From: Simon Davis
Sent: 26 April 2022 11:31
To: Planning Scanning
Subject: FW: Planning Re-Consultation on: Y/32/22/DOC & Y/39/22/DOC

From: Laura Gibbons [REDACTED]
Sent: 26 April 2022 10:02
To: Planning.Responses [REDACTED]
Cc: Simon Davis [REDACTED]
Subject: RE: Planning Re-Consultation on: Y/32/22/DOC

Engineers Comments Regarding Condition 8

Hydrobrake chamber (type 1, simple control)  
Scale 1:20

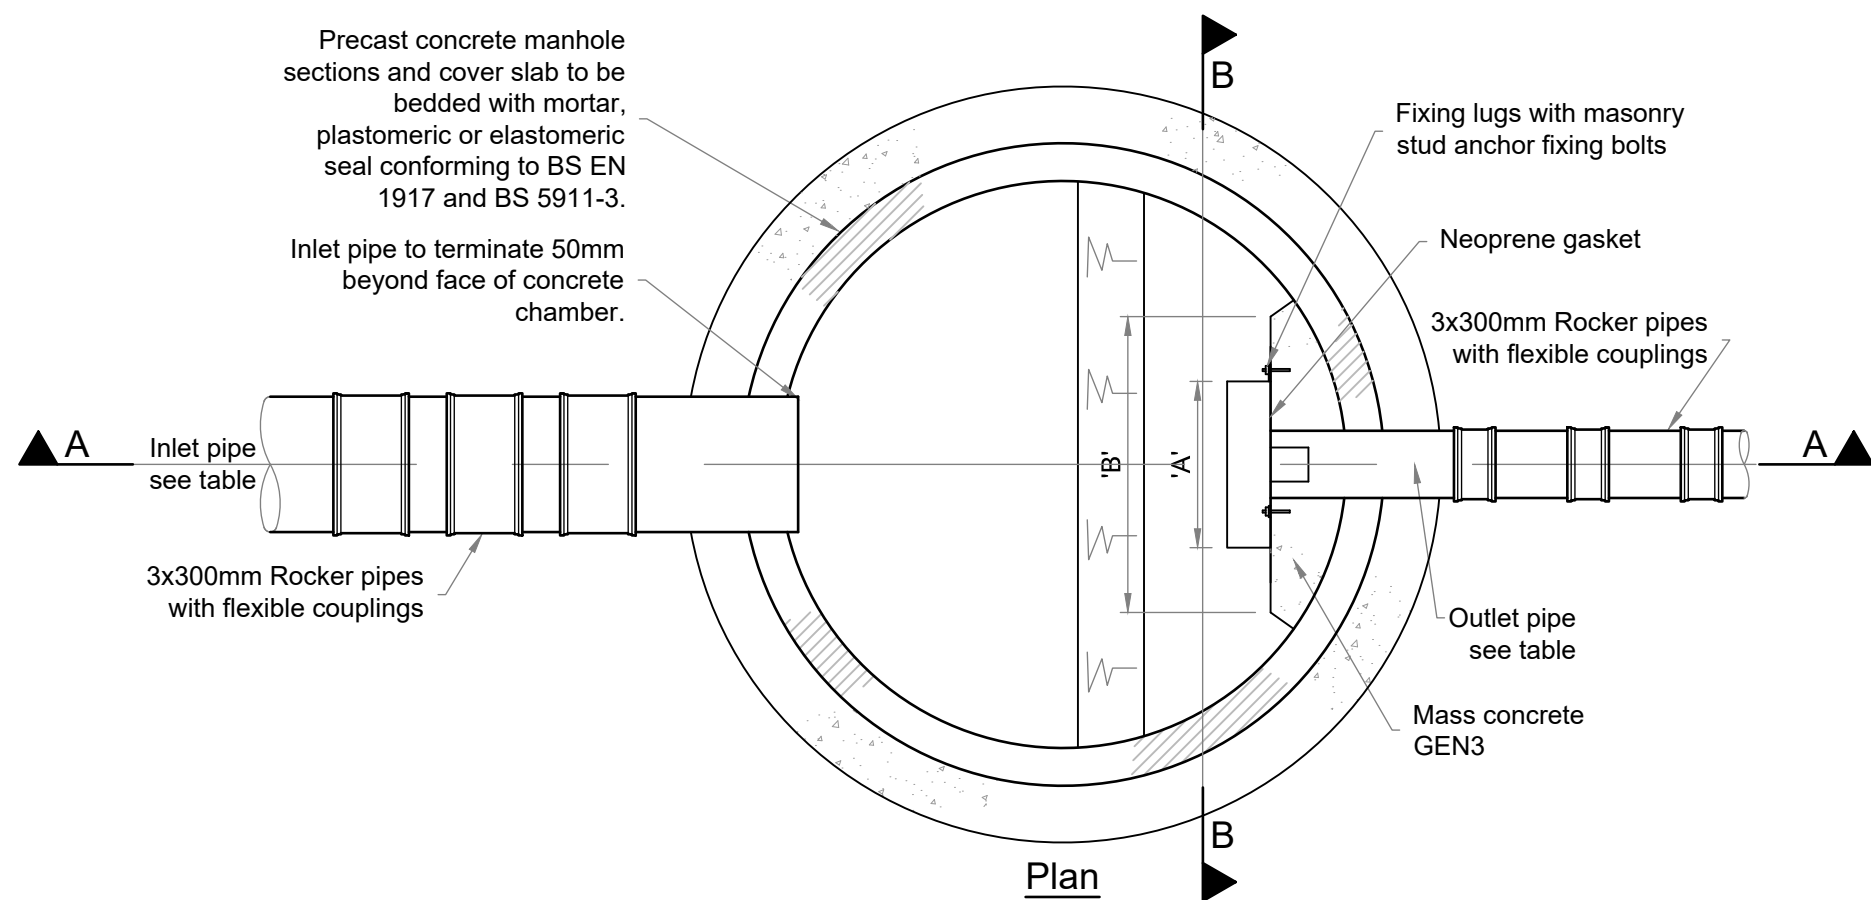
5. Hydrobrake unit references should be included on layout plans. Details have been added to updated drainage layout plan 13591-CRH-XX-XX-DR-C-5051 Revision P5. Okay, but please see comment above for more detailed calculations to evidence a compliant design. Hydrobrake reference on plans matches the calculations.

Project No.	Originator	Volume	Lvl/Loc	Type	Role	Number	Rev
13591	CRH	XX	XX	DR	C	5050	P6

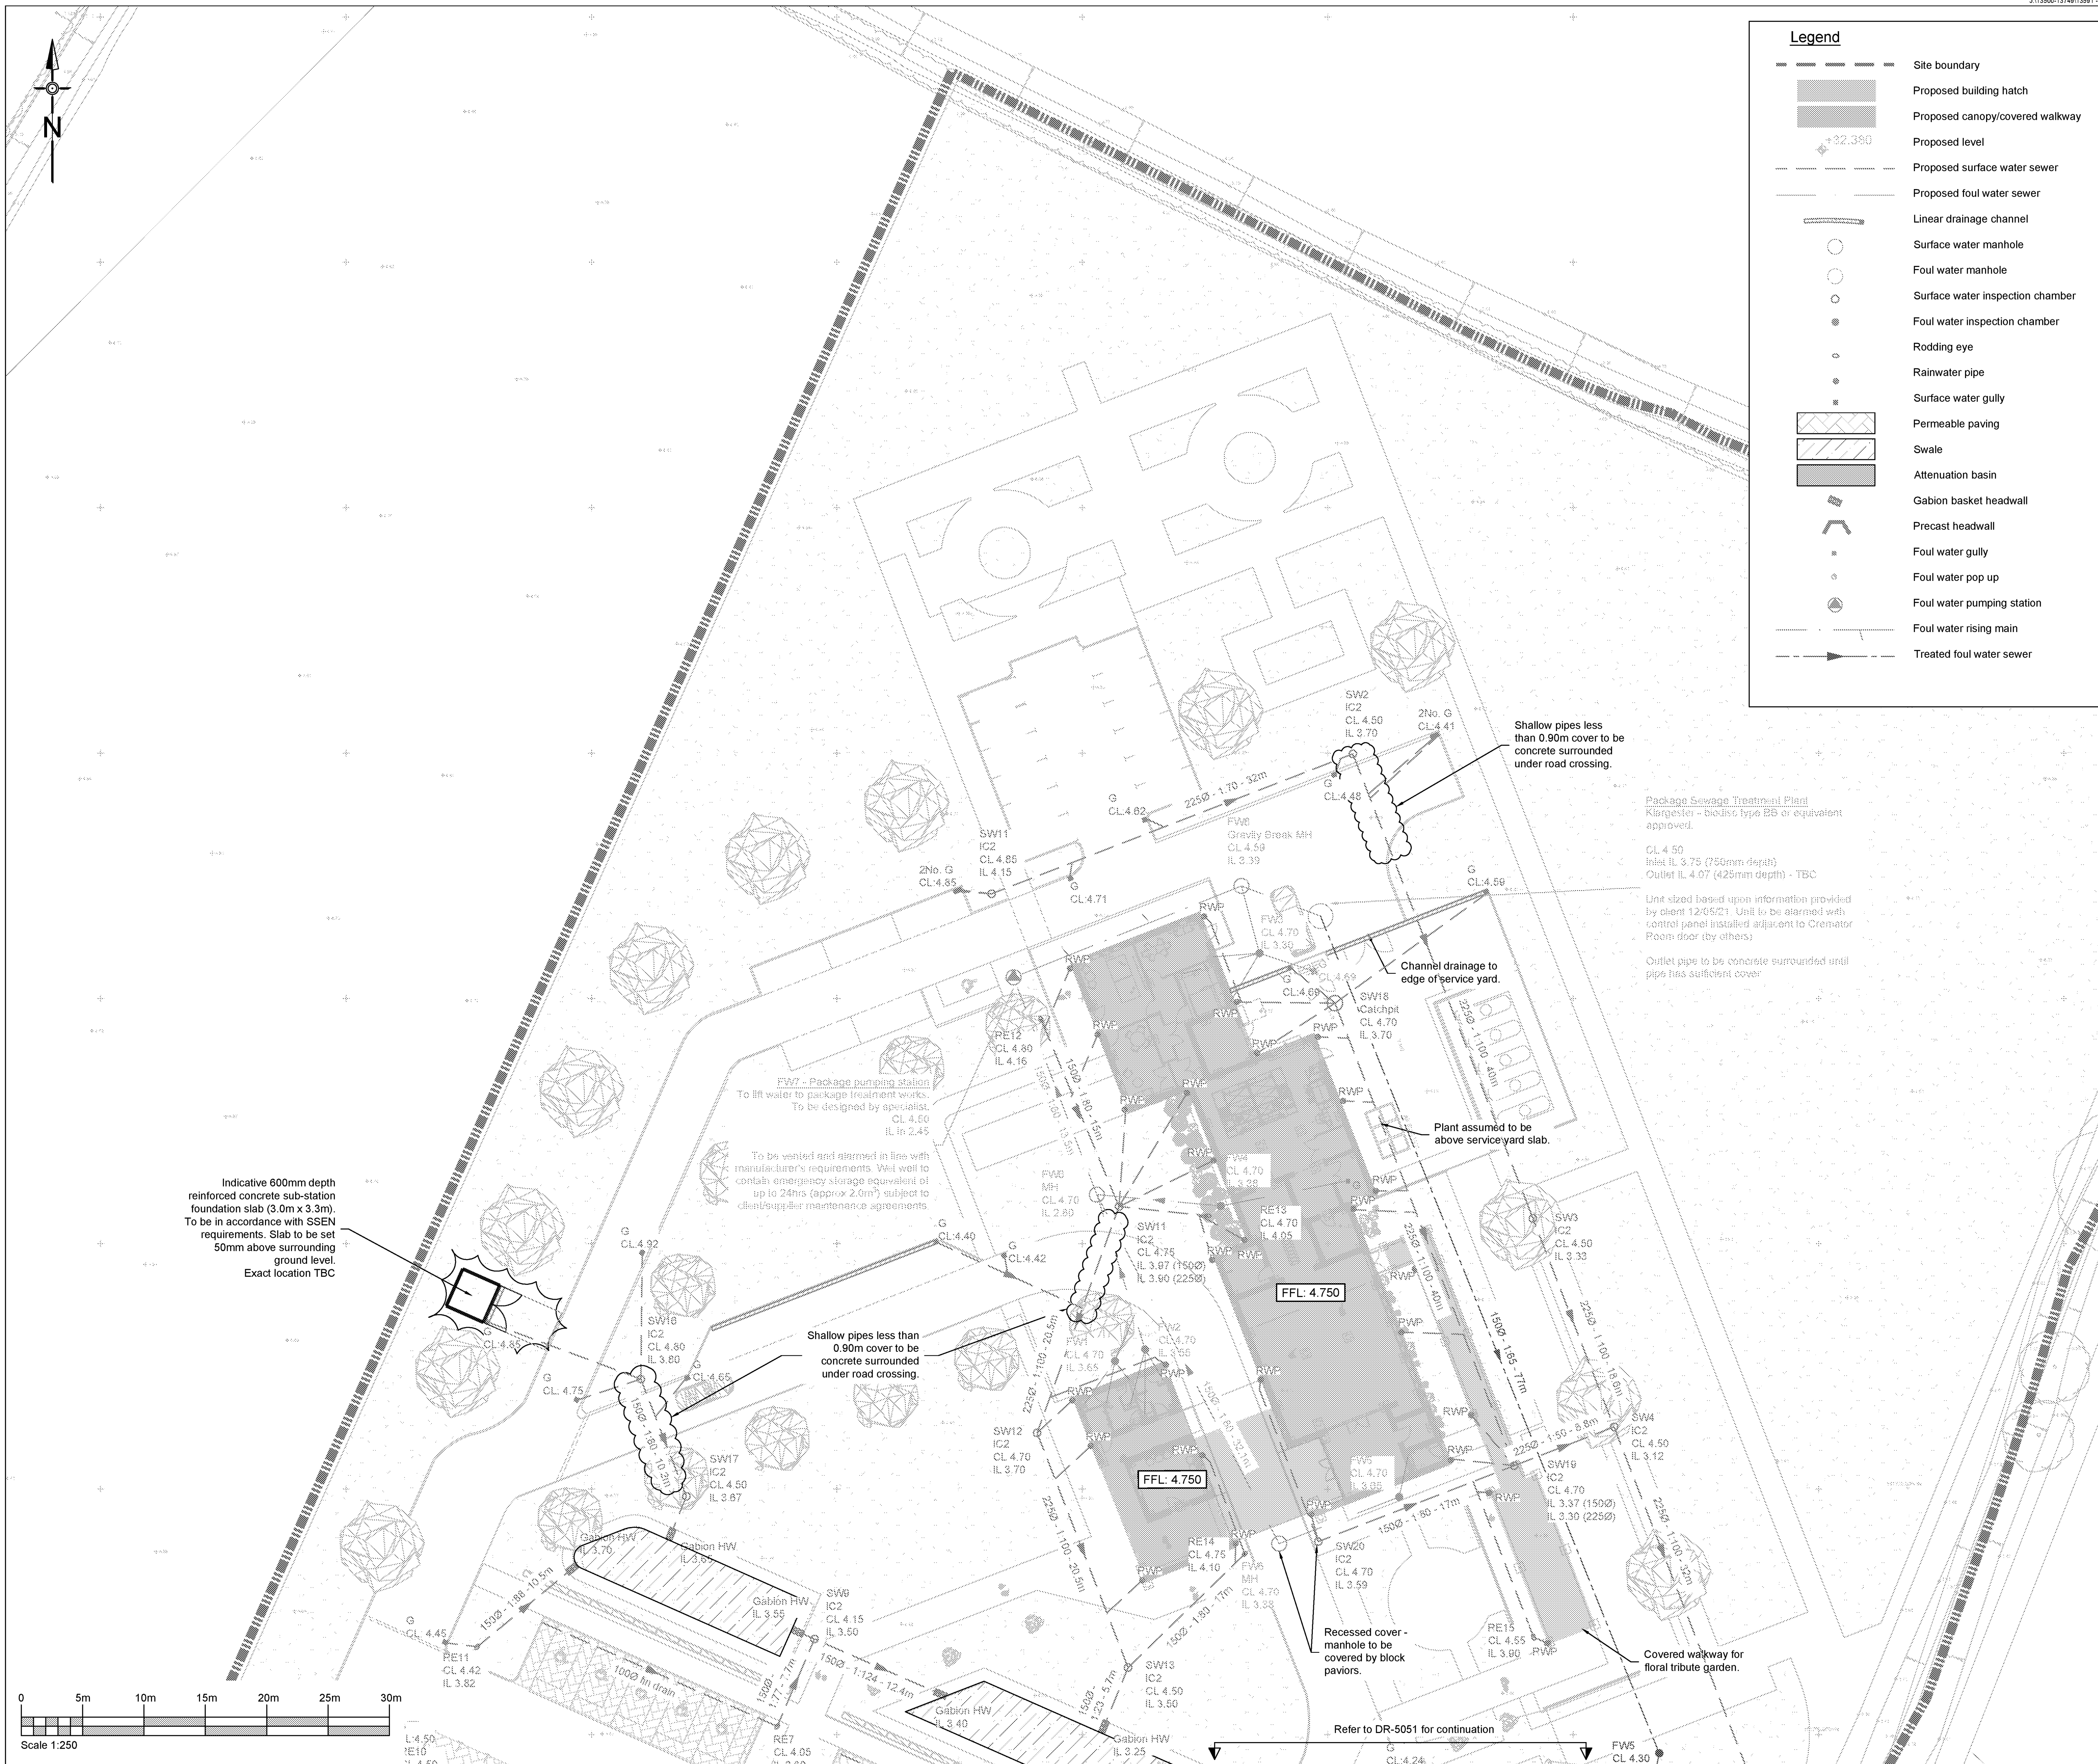
4. Please label all pipes with diameter and fall. Additional pipe labels have been added to drainage layout plans 13591-CRH-XX-XX-DR-C-5050 Revision P6 and 5051 Revision P5. Gradients for short (<5m) pipe lengths have not been shown. Pipe sizes, maximum grades and materials are to be as specified on drainage notes drawing 13591-CRH-XX-XX-DR-C-5300 Revision P1 previously provided. Okay.

7. Gullies and channel drains should be labelled with cover levels. Cover levels have been provided for proposed gullies on updated drainage layout plan 13591-CRH-XX-XX-DR-C-5050 Revision P6 and 5051 Revision P5. Channel drain cover levels will necessarily vary along the length and hence have not been provided. Exact levels will be determined by contractor to suit the finished levels as shown on levels plan 13591-CRH-XX-XX-DR-C-5200 Revision P3. Levels should be provided on plan to ensure construction is carried out in accordance with proposals. Channel drain cover levels have been added to drawings DR-5050 and 5051 as requested. To be reviewed once an updated set of calculations is provided.

2. Please supply a buffer plan to show that at least 3m is being provided between top of bank of watercourses and obstructing features, such as fences, buildings, and basins. A suitable buffer has been provided between top of basin and edge of watercourse to allow for maintenance, as shown on drawing 13591-CRH-XX-XX-DR-C-5051 Revision P5. *Buffer not clearly shown, please show the buffer on a plan. A buffer has been shown on drawings DR-5050 and 5051 as requested. Okay.*

Project No.	Originator	Volume	Lvl/Loc	Type	Role	Number	Rev
13591	CRH	XX	XX	DR	C	5250	P1

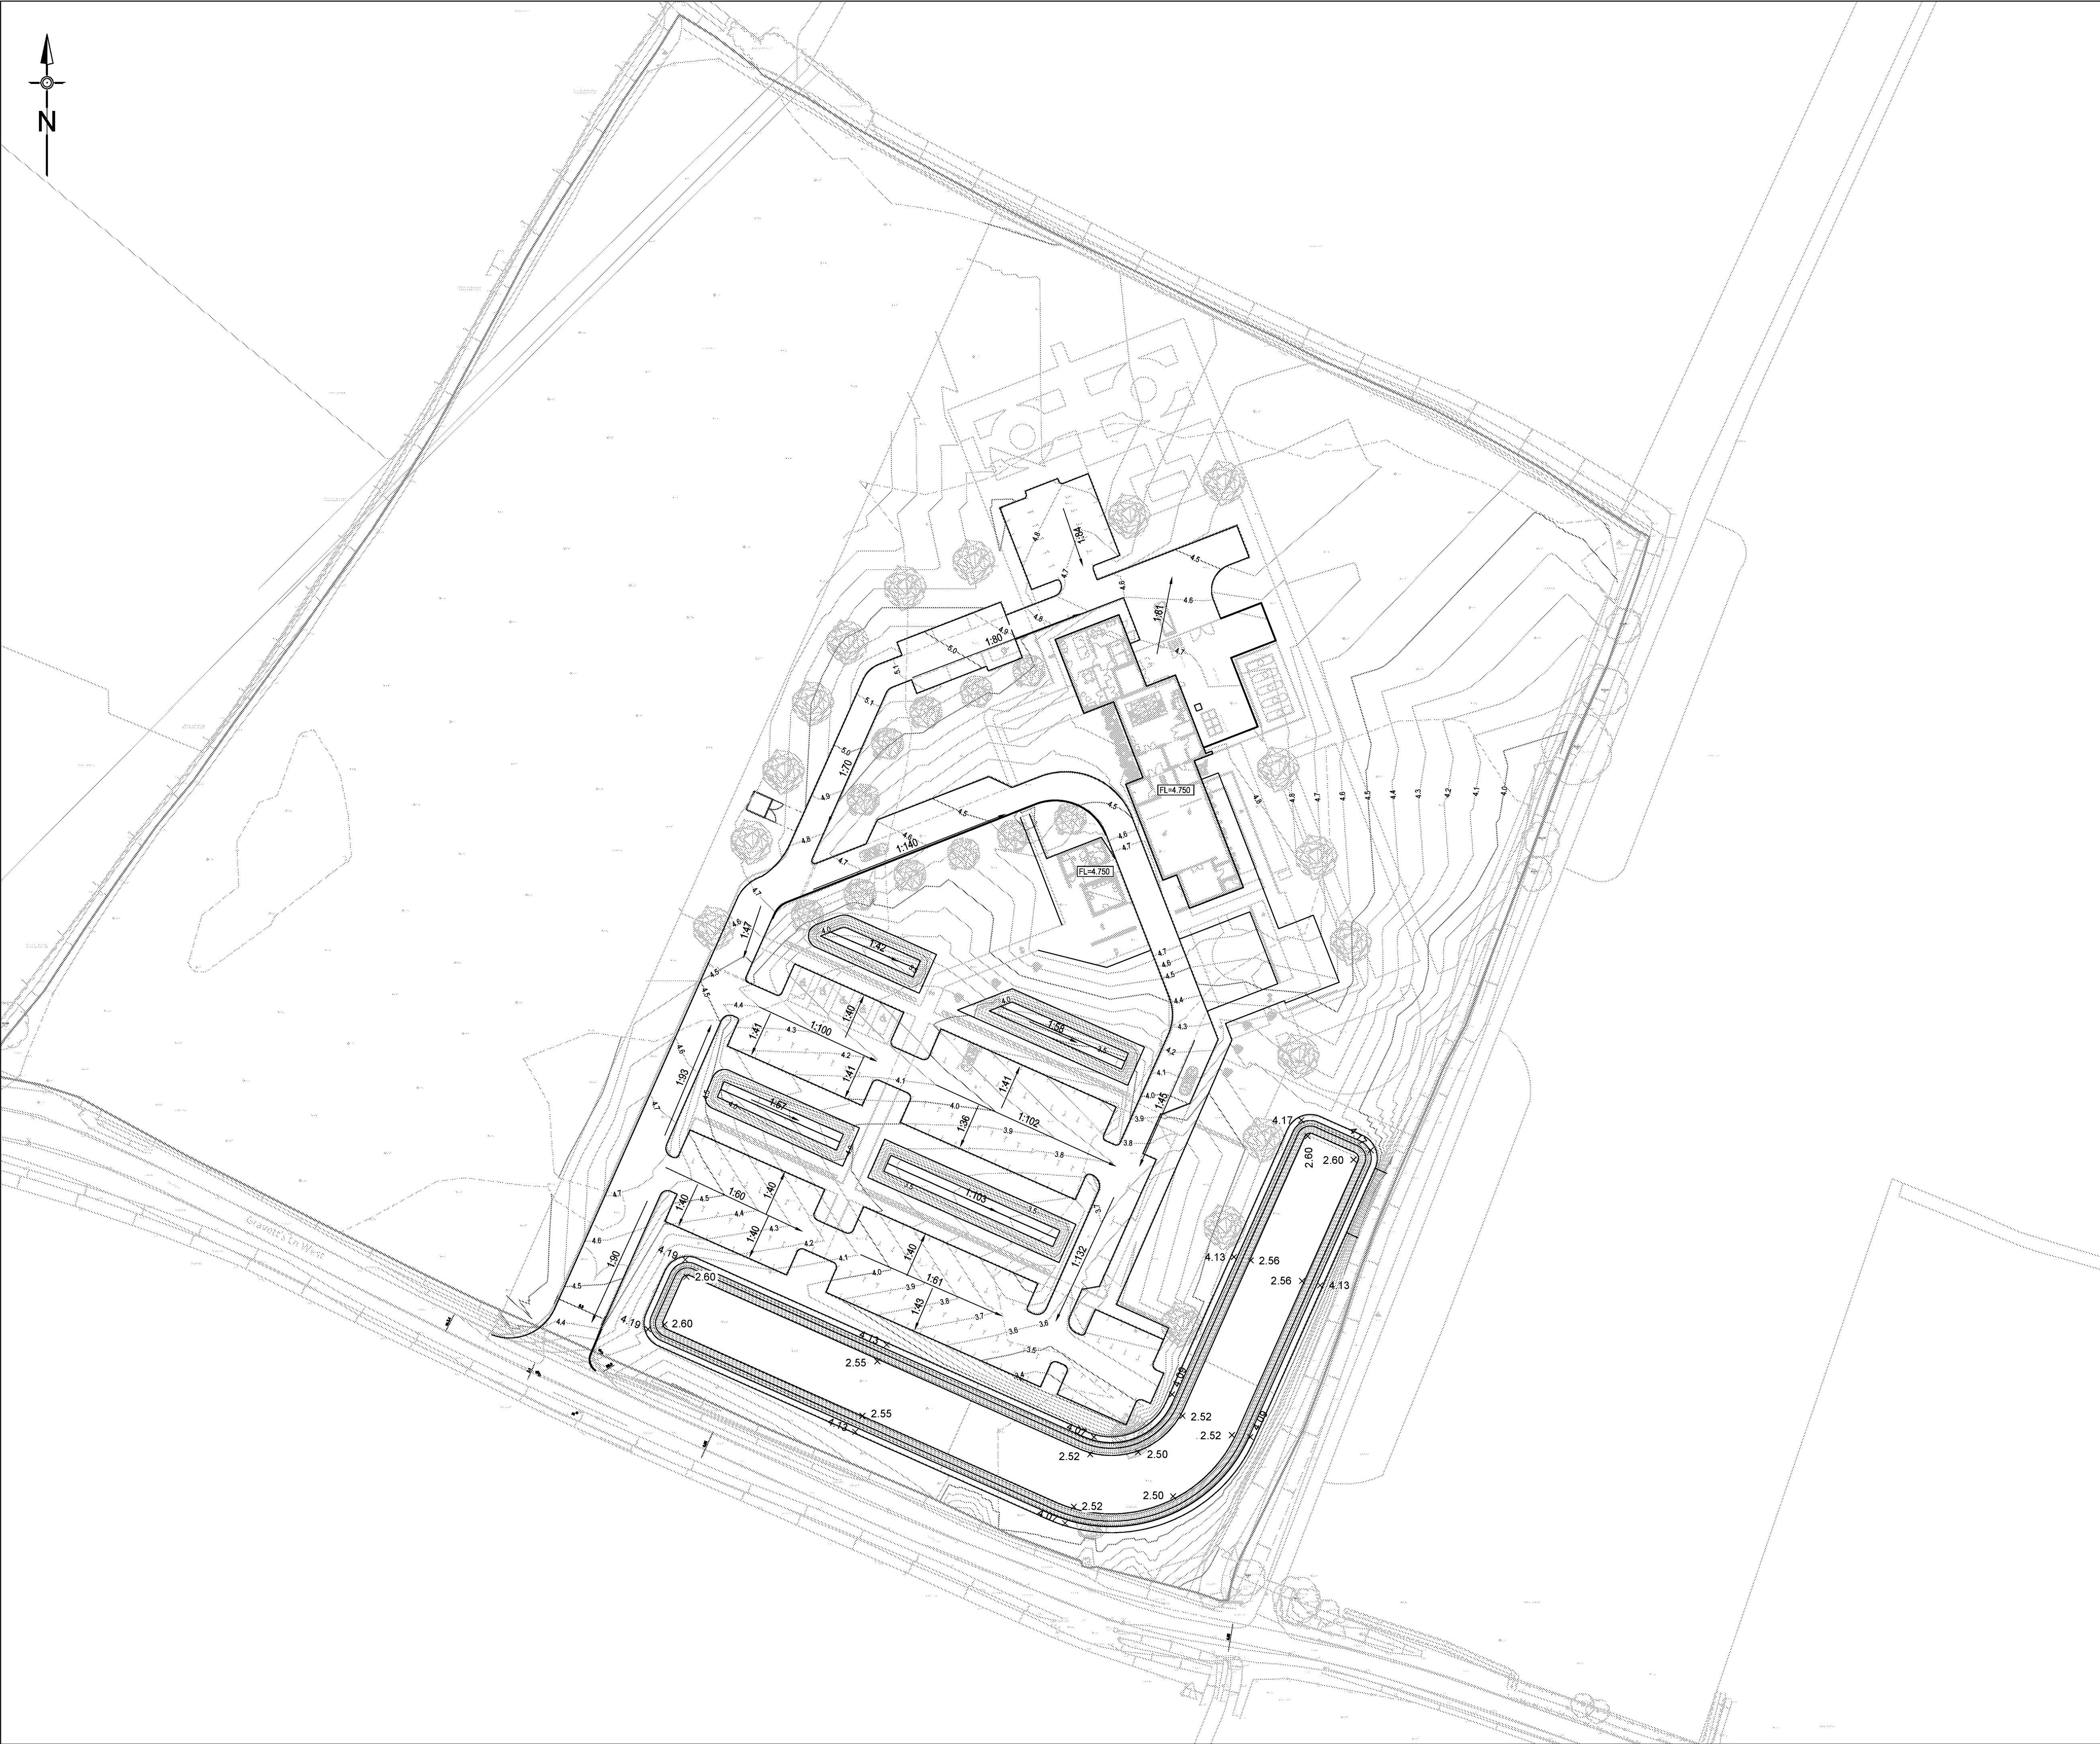
3. Please supply an impermeable area catchment plan. Please see enclosed impermeable area plan 13591-CRH-XX-XX-DR-C-5250 Revision P1. Okay. We have also included the additional detailed sub-catchment plan 13591-CRH-XX-XX-DR-C-5260-P1 to accompany the drainage calculations and provide absolute clarity as to which areas contribute to the model. To be further reviewed once points 1 and 2 are addressed.
